RE: MEDRANO CONCRETE, INC. (G-14/D69)
(122 Headingly NW)
ENGINEERS CERTIFICATION FOR CERTIFICATE OF OCCUPANCY
ENGINEERS STAMP DATED 8/2/2002
ENGINEERS CERTIFICATION DATED 3/4/2003

RE: MEDRANO CONCRETE, INC. (G-14/D69)
Grading and Drainage Submitted for Building Permit Approval
ENGINEERS STAMP DATED 8/2/2002

Re: Certification Submittal for Final Building Certificate of Occupancy for
Medrano Concrete Office Bldg., [G-147 D069]
122 Headingly N.E.
Architect's Stamp Dated 07/22/02

SITE PLAN

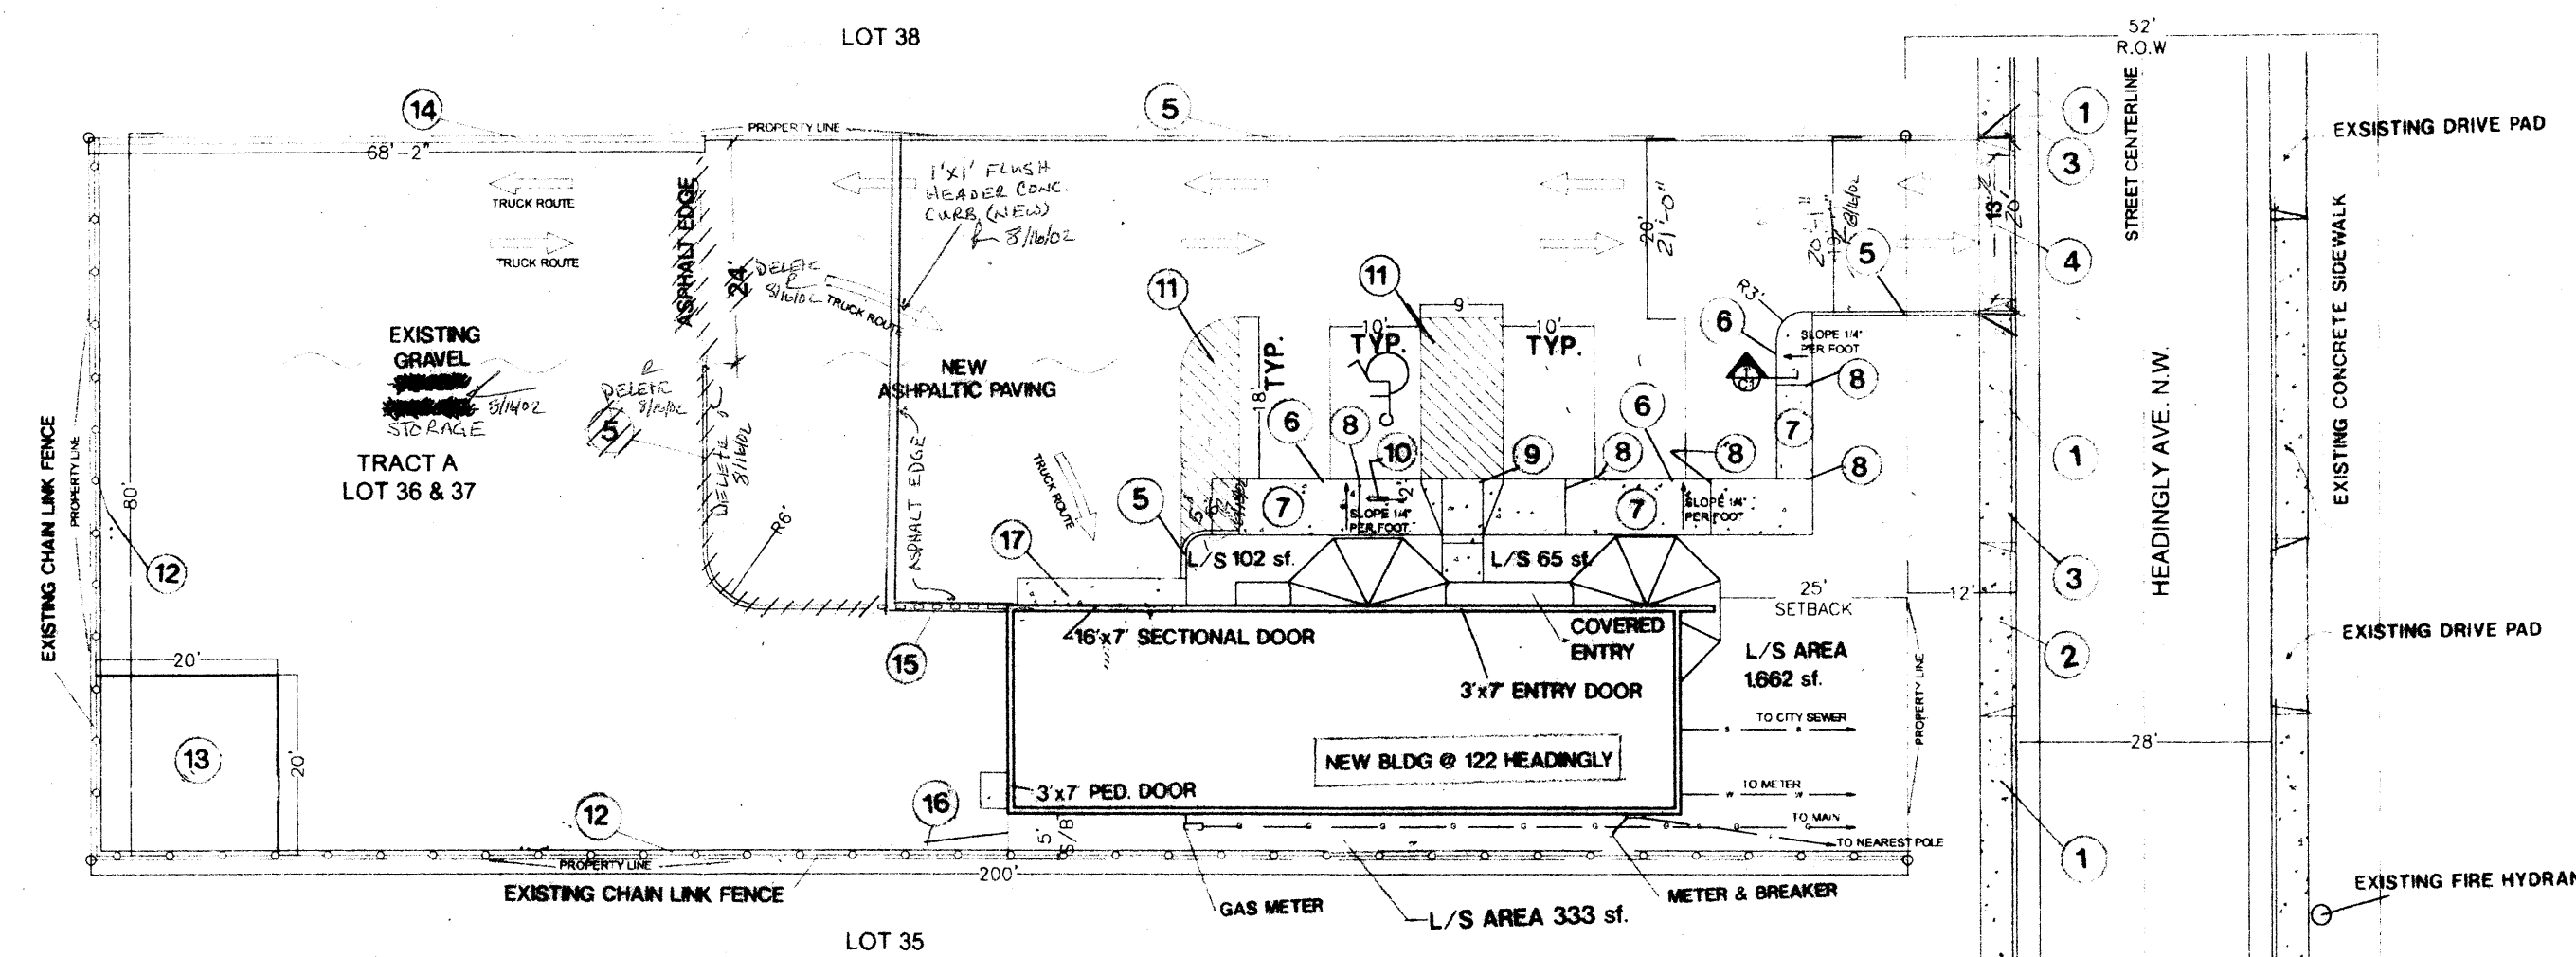
Site visit reveals a building existing on the site. Show the old building in light, dashed linework on the TCL and call out as being demolished, or similar, if applicable.
